## Response to Agency and Public Submissions

DRAWING TITLE			
RETAIL 75W APPLICATION SOUTH AND EAST ELEVATIONS			
SCALE			
AS SHOWN			
PROJECT NUMBER			
15R Wool			
DRAWING NUMBER			
DA17			
ISSUE			
A			
A1

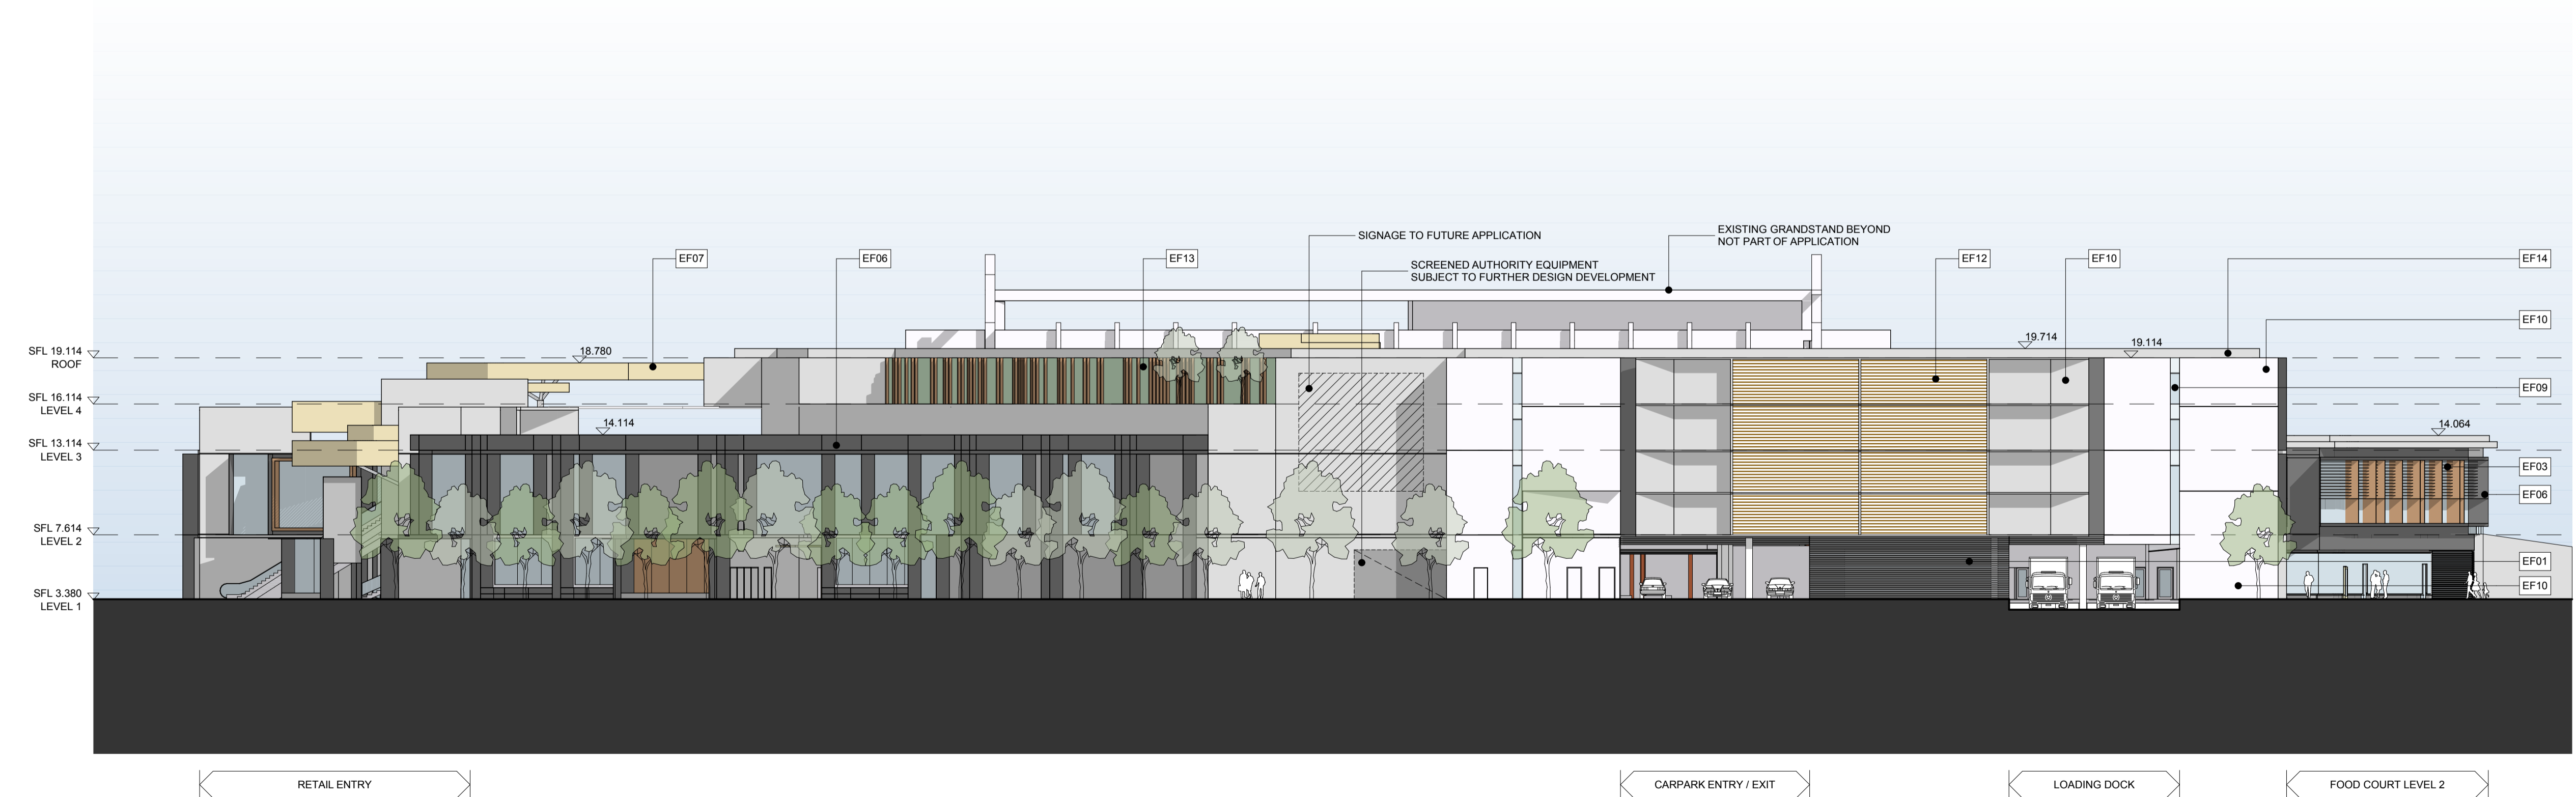
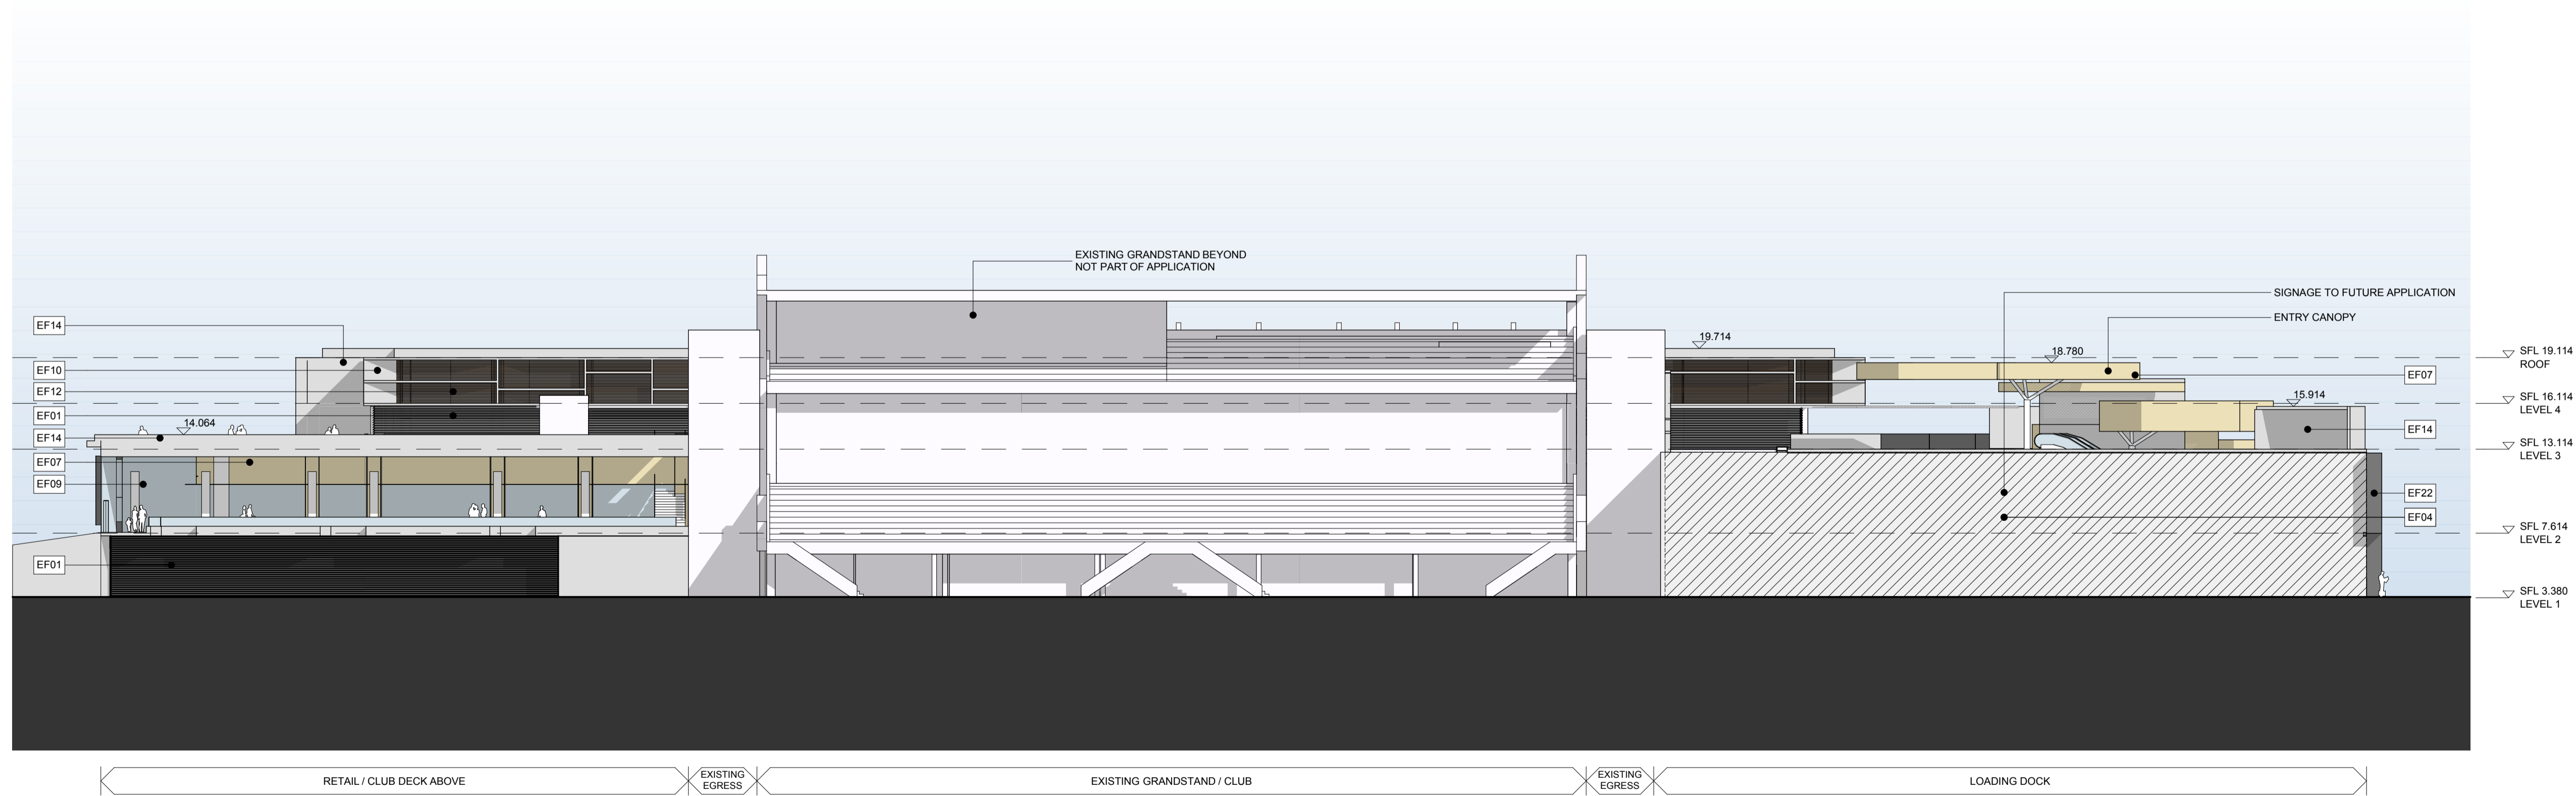
<p><b>Visual Impact</b></p> <p>The applicant has casually proposed a roof for Level 4 car park which would be equivalent to half a storey increase with consequent increased visual impact.</p> <p>However a greater threat is that the roof itself could become an extra car park level to accommodate parking needs for some future application for even more development. Alternatively it may be a “Plan B” for when their under-provision of parking, as highlighted by Sutherland Shire Council and many submitters to the various proponent applications, becomes proven by overflow parking in local streets as a demonstration of the failure of the development assessment system to prevent inappropriate development such as the Sharks enclave. The proposed reshuffle of parking between levels 3 and 4 would sneak in another 24 car parking spots but this will not be enough.</p>	<p>The existing Concept Approval provides for a higher roof structure above the L4 car park.</p> <p>This is not proposed, and in any case the change suggested would require separate planning approval that would be subject to the normal notification and merit assessment processes.</p>
